**REF: 22/02785/PRE - PRE-PLANNING FEEDBACK**  
**751 Broomfield Road, Glasgow, G21 3HQ**

Figure 2: Access to Local Amenities

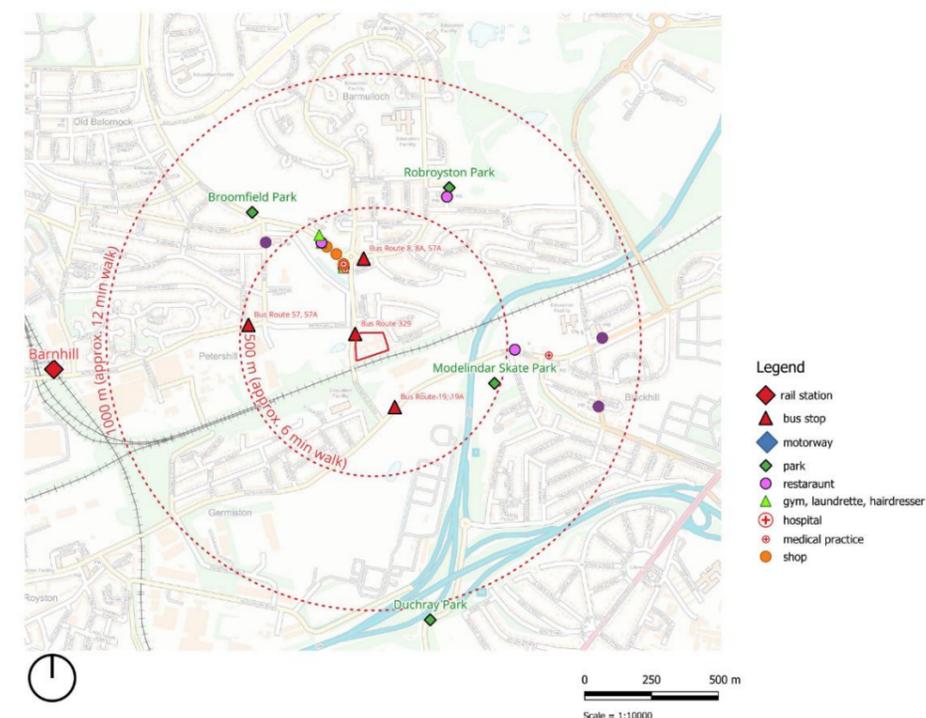
<b>PLANNING OFFICER QUESTION</b>	<b>OUR RESPONSE</b>
1	Please could the distances to local facilities be reviewed as they do not appear to match distances internally. The distance should be the shortest walk, not from point to point.	Walking and cycle distances have been updated.
2	It is suggested that a privacy strip with some soft landscaping be introduced to ensure sufficient retention of privacy for the private gardens. In addition, re-orientation of the parking may assist to avoid headlights shining through to the private gardens.	Wooden fencing will be added to enhance privacy and prevent headlights shining through to private gardens.
3	A swept path analysis demonstrating the ability of the site to accommodate any deliveries, bin lorries, and fire vehicles.	Swept path analysis performed and demonstrates existing site can accommodate delivery trucks, bin lorries and fire vehicles.
4	Further details about the landscaping arrangements to the south of the site, especially the area proposed to be screened off. We would resist any hard landscaping and suggest soft landscaping could assist with creating a degree of separation between the proposed hostel and open space/assumed water vole habitat.	Only soft landscaping proposed to separate outdoor guest area from open space/assumed water vole habitat.

APPENDIX 8: Figure 17: Proposed Bin and Cycle Storage

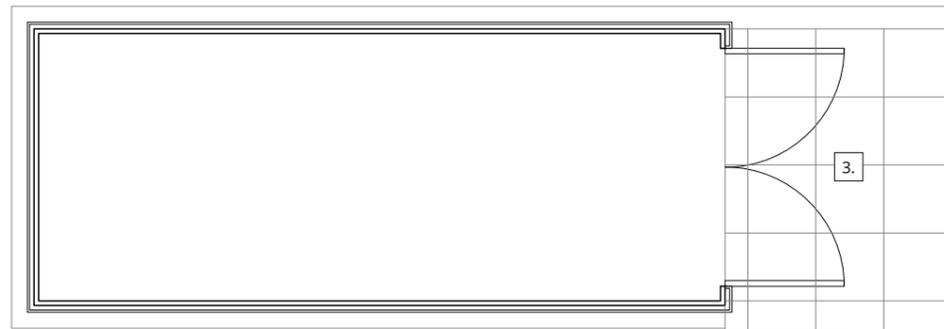
8	The proposed siting of the bin store is not acceptable. Is there scope to move this internally by removing a bedroom or two? Alternatively, if to be site externally, it should not be sited along the front elevation or where it is visible from the public road.	For fire safety and insurance purposes, the bins cannot be located internally. The bins will be stored externally in lockable outdoor sheds made of metal structure with wooden cladding and are aesthetically pleasing to the local surroundings.
9	In terms of the cycle storage further details are required about the design of this building, including proposed materials. There is some concern about its positioning and again it is suggested that the potential to site it internally be explored.	We propose significant cycle storage, no room is capable of holding so many cycles. The cycles will be stored externally in lockable outdoor sheds made of metal structure with wooden cladding and are aesthetically pleasing to the local surroundings.
